February 13, 2015

RE: Anderson Street Monuments

I am glad we had the opportunity to talk this week regarding your Redfern Properties, LLC Plan dated July 21, 2014 and revised on Sept. 2, 2014. I noticed that your plan showed an area of discrepancy along the street line of Anderson Street and I wanted to share some information with you that may resolve that discrepancy.

Plan Depicting The Results Of A Boundary, Topographic & Existing Conditions Survey Made For Redfern Properties, LLC Southeastery Sideline Of Fox Street, Northeastly Sideline Of Anderson Street, & Northwestery Sideline Of Everett Street Portland, Maine

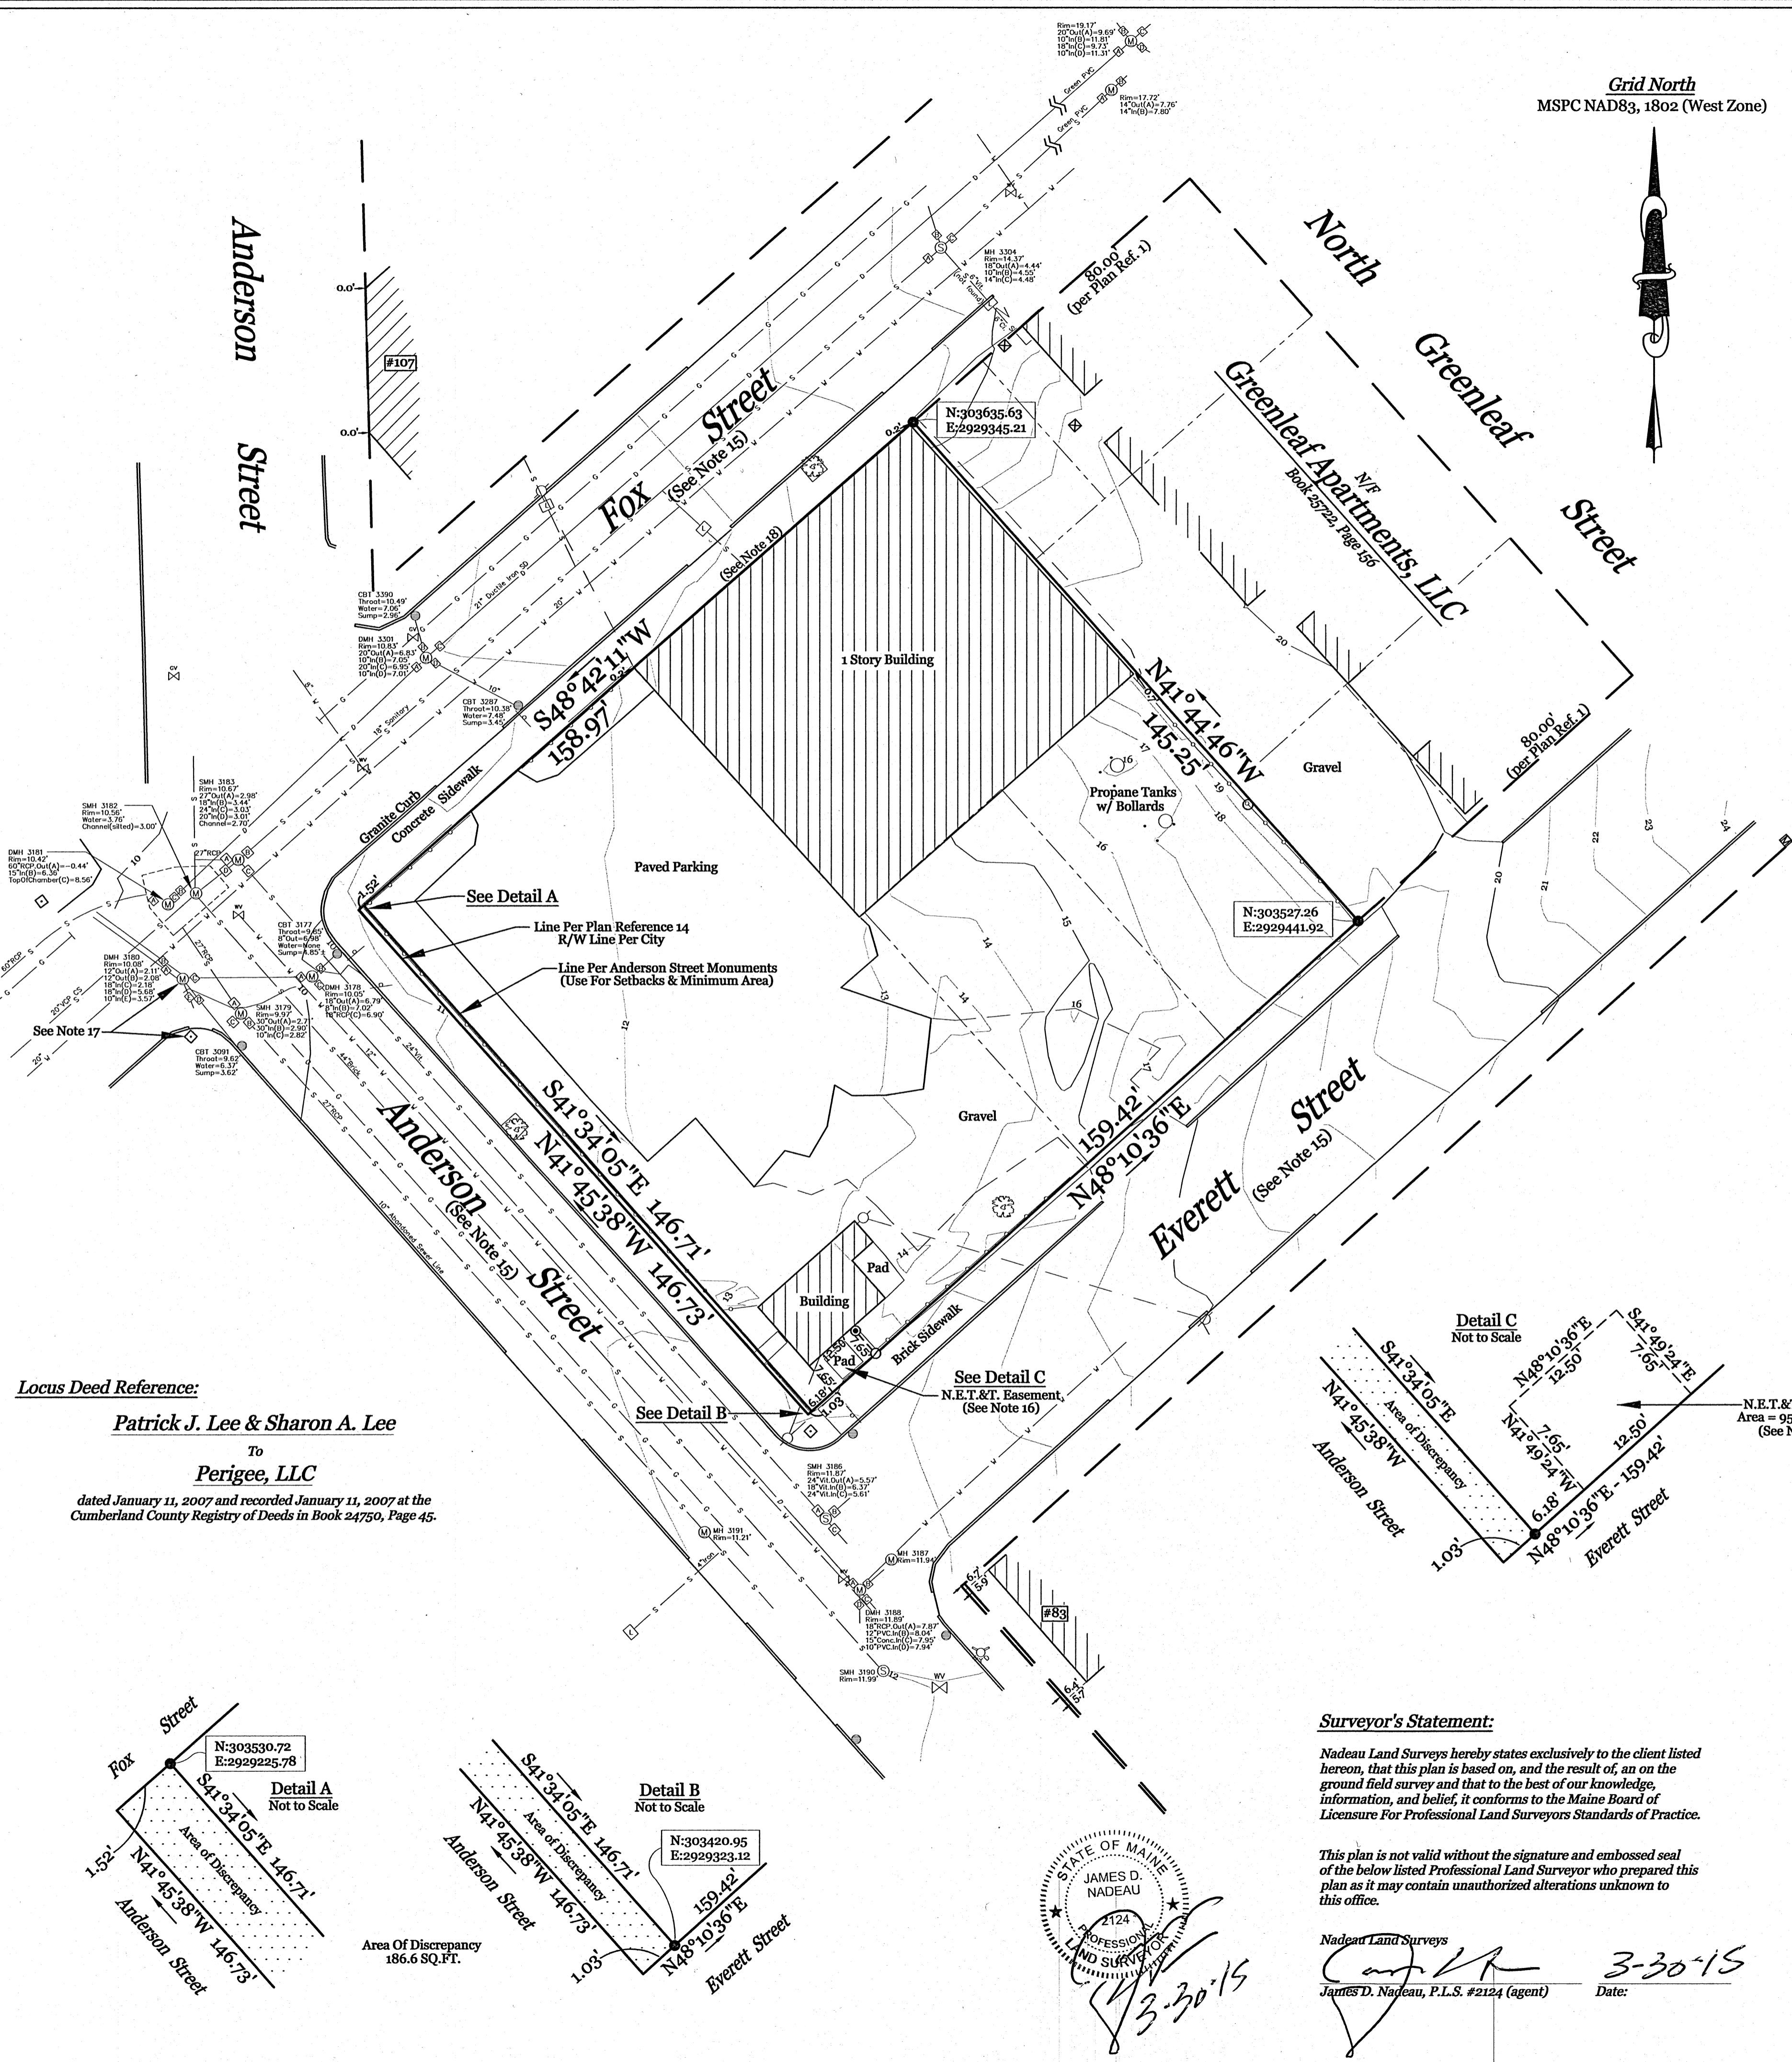
Any original monuments along Anderson Street (between Fox St. and Cumberland Ave.) were destroyed prior to or during the re-construction of Anderson Street in the early 1990's. (The monument at the corner of Anderson and Lancaster appears to be the original monument and does **not** appear to be reset. However, the top of the monument has been cut down and the bolt is a hex bolt, whereas before 1992 it was not.) The monuments that are out there now were reset in 1992-93 by a contractor and not by the City. I have not yet found the survey records that show how the four monuments were reset.

Based on two surveys that I performed in the area between 2012 and 2013, I found that the monuments at Fox, Everett, Madison and Monroe Streets did not appear to be set on the 3 foot offset line of Anderson Street. None of the monuments agreed with one another. As a result, I did not use those monuments to establish the street line for Anderson Street. I used other monumentation on Fox Street, the monument at Lancaster St. and several historical records found in our engineering vault. This information is shown in the City's digital CAD plan that you reference in your Plan Reference Note #14 and that we sent to you on May 15, 2014. The line for Anderson Street as shown on the City's CAD plan is my best determination of the street line based on the facts available to me at the time. Of course, as is true with almost any survey, if I performed a larger more encompassing survey, I may come up with a slightly different line.
